Condition 11 of planning permission AB/60/17/PL states:

To meet the requirements of Condition 11, we will require an auditable trail of site supervision by the project arboriculturist, with supporting photographic evidence. The report will need to demonstrate full compliance at all stages of work with the Method Statement, RW Green Limited – 13.5.19 RWG, if damage of the oak tree is to be limited to a tolerable level and capable of satisfactorily discharging Condition 11.

Condition 10 states : All demolition and construction works are to be carried out in strict accordance with:
Arboricultural Method Statement Report Ref ACD Environmental - PR117371tr-Rev E - 27.03.17 and Tree Protection
Plan ref: ACD Environmental - P117371-03D-1:100@A2.

dwg no: PR117371-03D

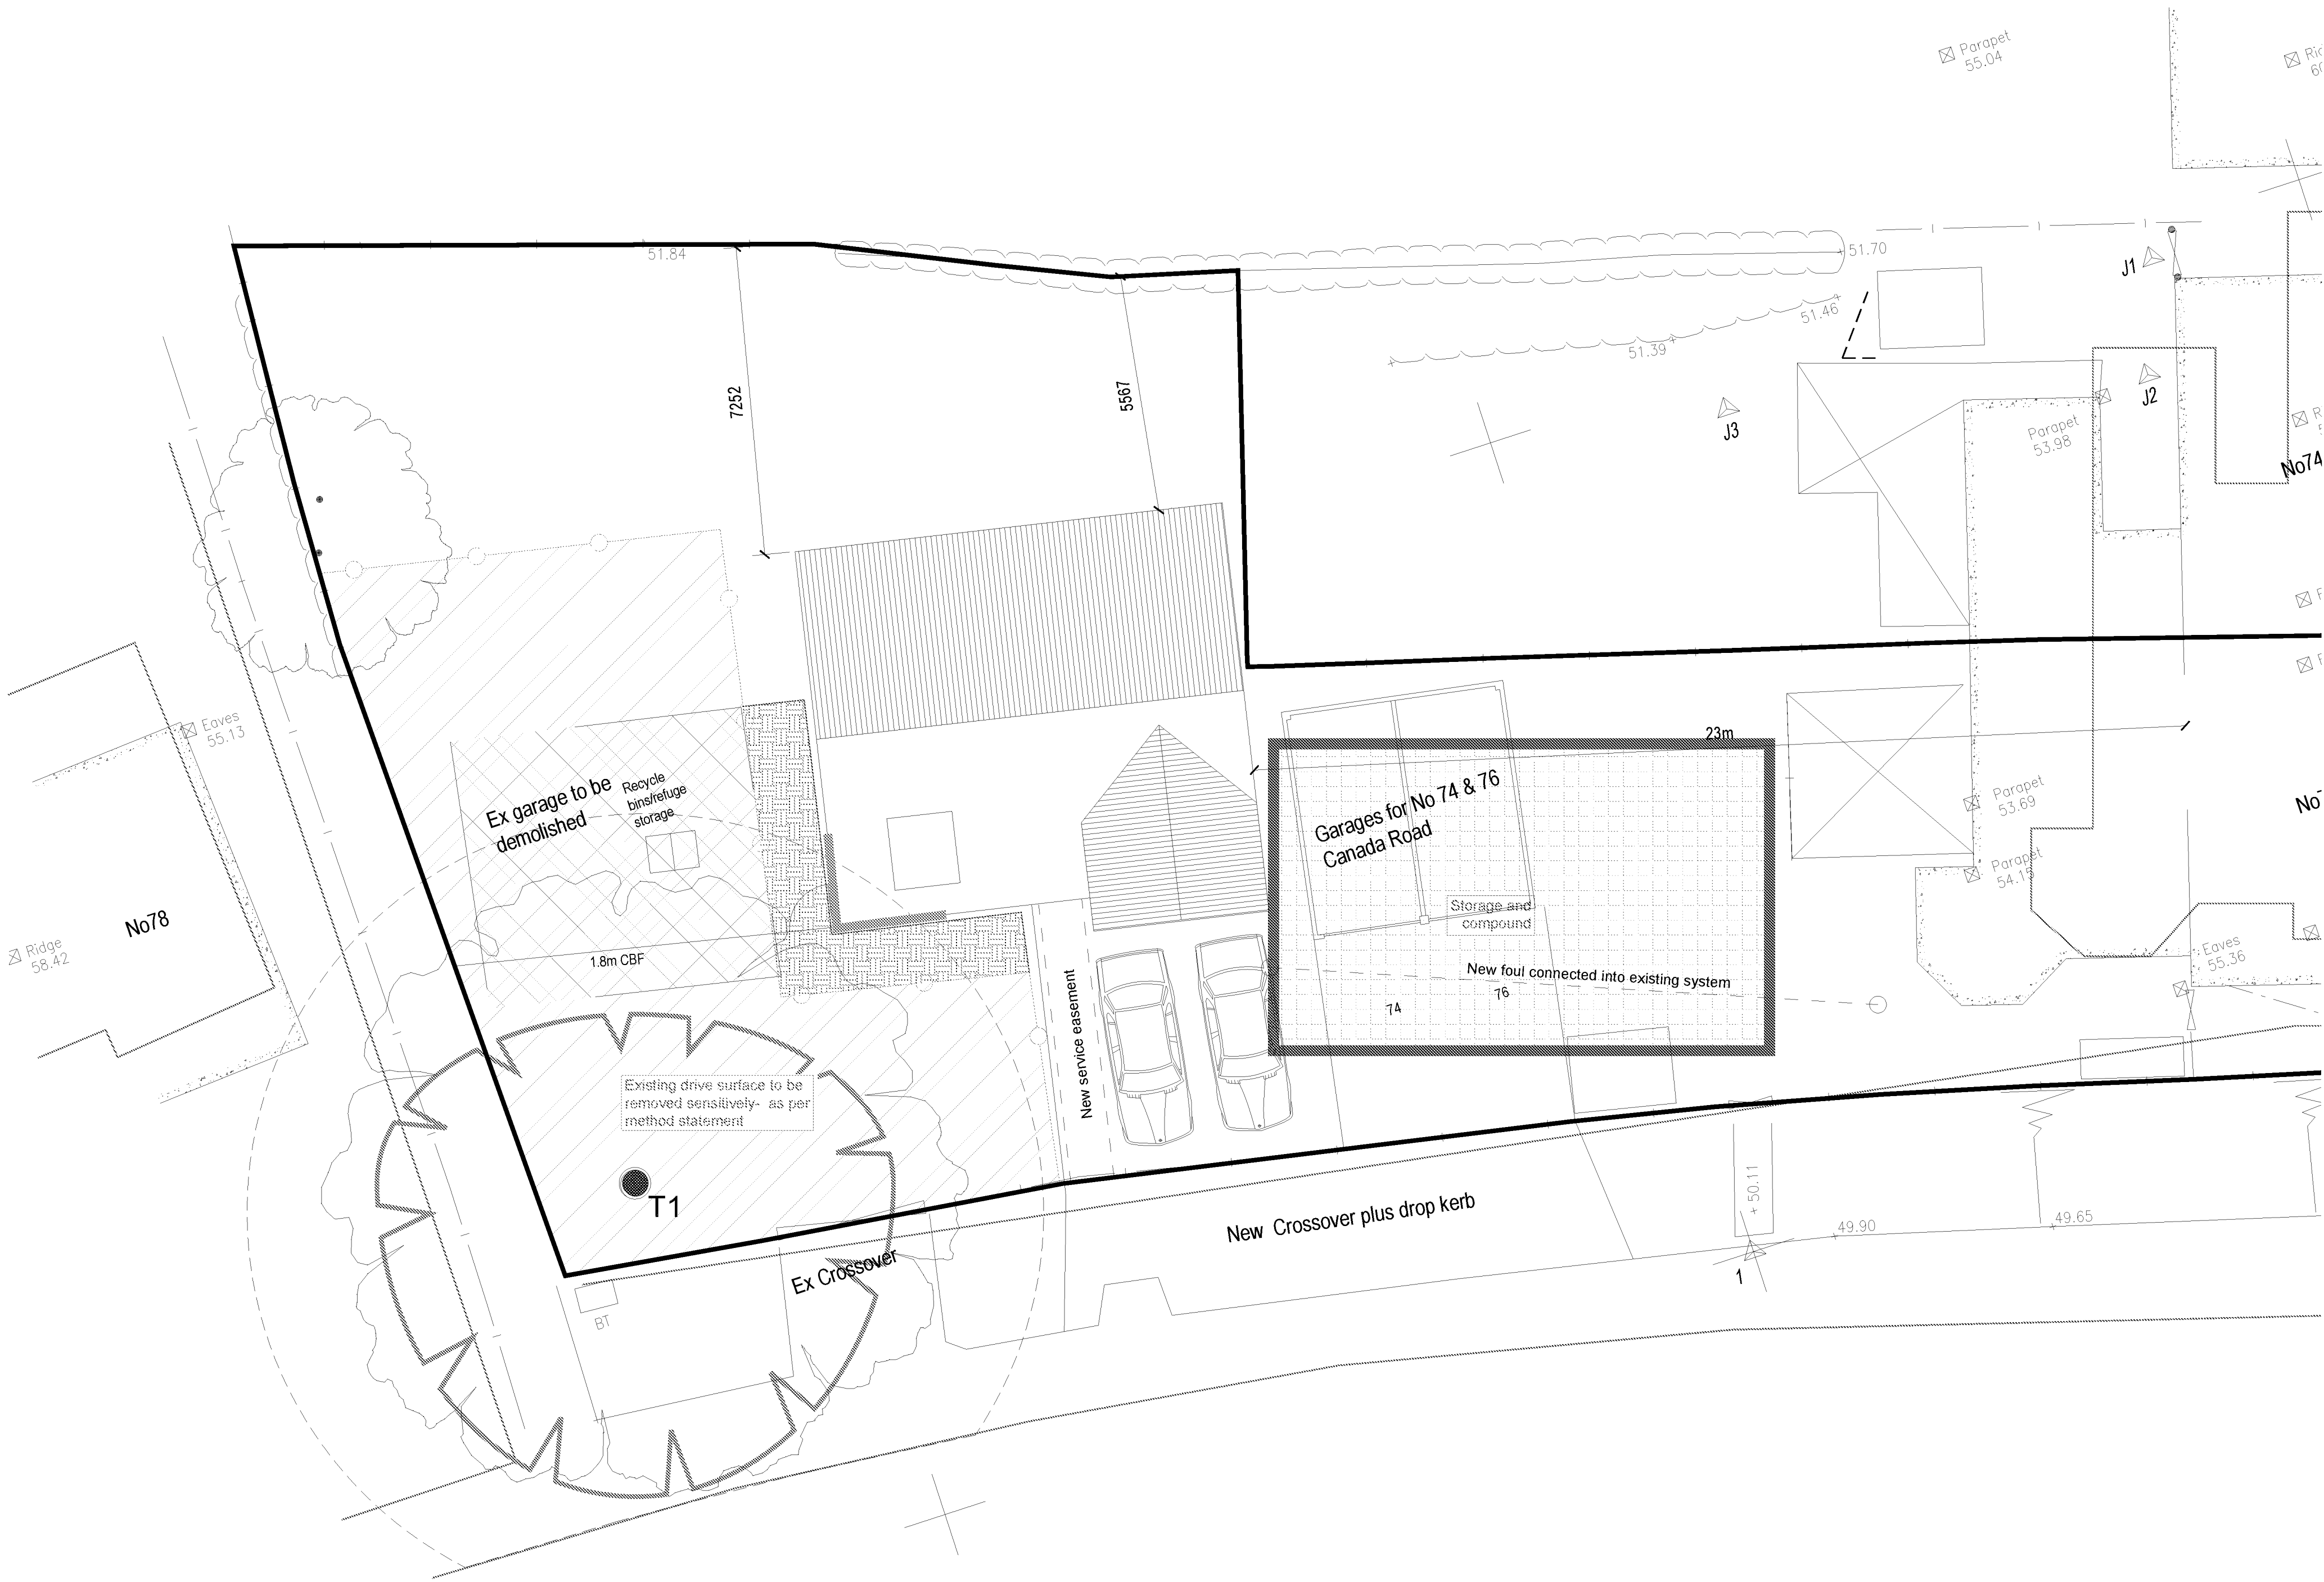
Our Engineers are asking for concrete encasement of pipework within the RPA and the Method Statement will need to be revised to detail the necessary protection of exposed soil profile/roots within the excavation from harmful effects of curing concrete which is highly toxic to plants. This can be done by pre-installing heavy duty polypropylene sheeting to prevent any contact during the curing process.

Therefore if the report or plan need to be amended to incorporate diversion of the pipe a variation of condition
application would need to be submitted for consideration.
